**WELWYN HATFIELD BOROUGH COUNCIL
EXECUTIVE DIRECTOR - PLANNING, PUBLIC PROTECTION AND GOVERNANCE**

DELEGATED APPLICATION

Application No: 6/2018/0369/HOUSE
Location: 113 Champion Road Hatfield AL10 9FL
Proposal: Erection of a single storey rear extension
Officer: Mr Richard Sakyi

Recommendation: Granted

Proposed Ground Floor Plan

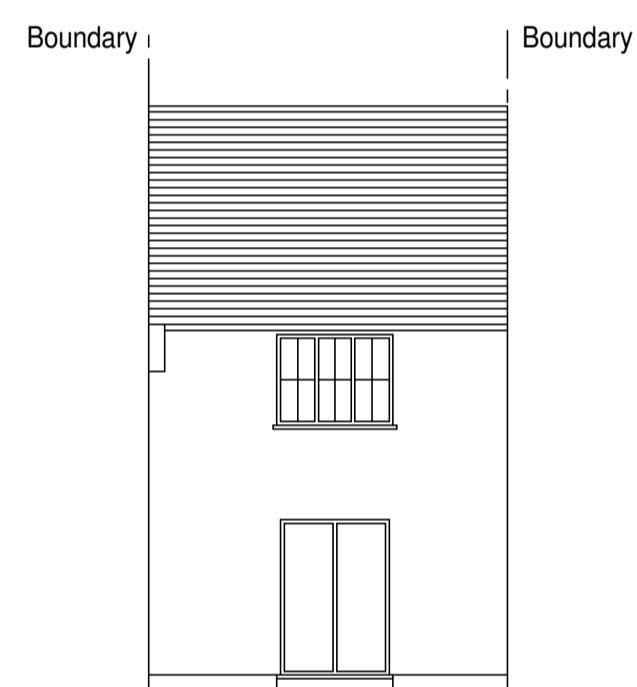
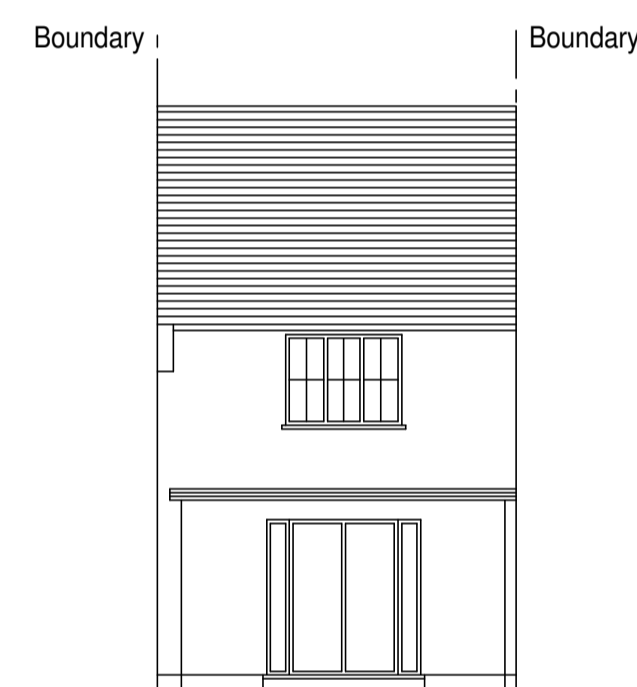
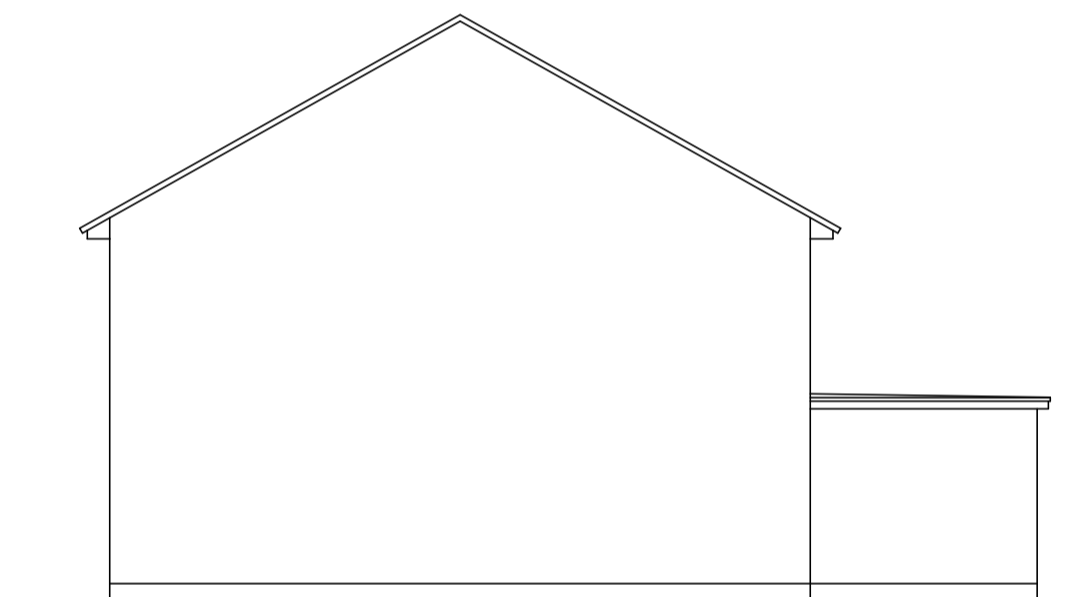
Would the development reflect the character of the dwelling?
<input checked="" type="checkbox"/> Yes <input type="checkbox"/> No <input type="checkbox"/> N/A Comment (if applicable):
<p>The proposed single storey rear extension would be subordinate to the host dwelling and would not detract from character of the dwelling. The proposed materials are to match the existing dwelling so on balance, it is considered that the design would relate well to the host dwelling and it follows that there is no conflict with Policies GBSP2, D1 and D2 of the adopted Welwyn Hatfield District Plan 2005 insofar as these seek to ensure that development is designed to a high quality, respects local character and context and is compatible with the character of Hatfield. The proposal further complies with the National Planning Policy Framework in terms of design.</p>
Would the development maintain the amenity of adjoining occupiers? (e.g. privacy, outlook, light etc.)

<input checked="" type="checkbox"/> Yes <input type="checkbox"/> No <input type="checkbox"/> N/A Comment (if applicable):
<p>The main property that would be affected is the adjoining property located on the north of the application property. There is a patio door on the ground floor at a distance of approximately 0.5m from the shared boundary of the application property which appears to serve a habitable room. Notwithstanding the above, the proposed extension with a maximum depth of 3m with a flat roof is considered acceptable. Furthermore, no windows would be inserted in the side elevation, therefore it is considered that there would be no adverse impact on loss of amenities in terms of overlooking, sun/daylight, outlook or privacy on the present level of amenity enjoyed by number 111 Campion Road to warrant the refusal of planning permission.</p>
Would the development provide / retain sufficient parking?

1. The brickwork, roof tile, bond, mortar, detailing, guttering, soffits and other external decorations of the approved extension/alterations must match the existing dwelling/building in relation to colour and texture.
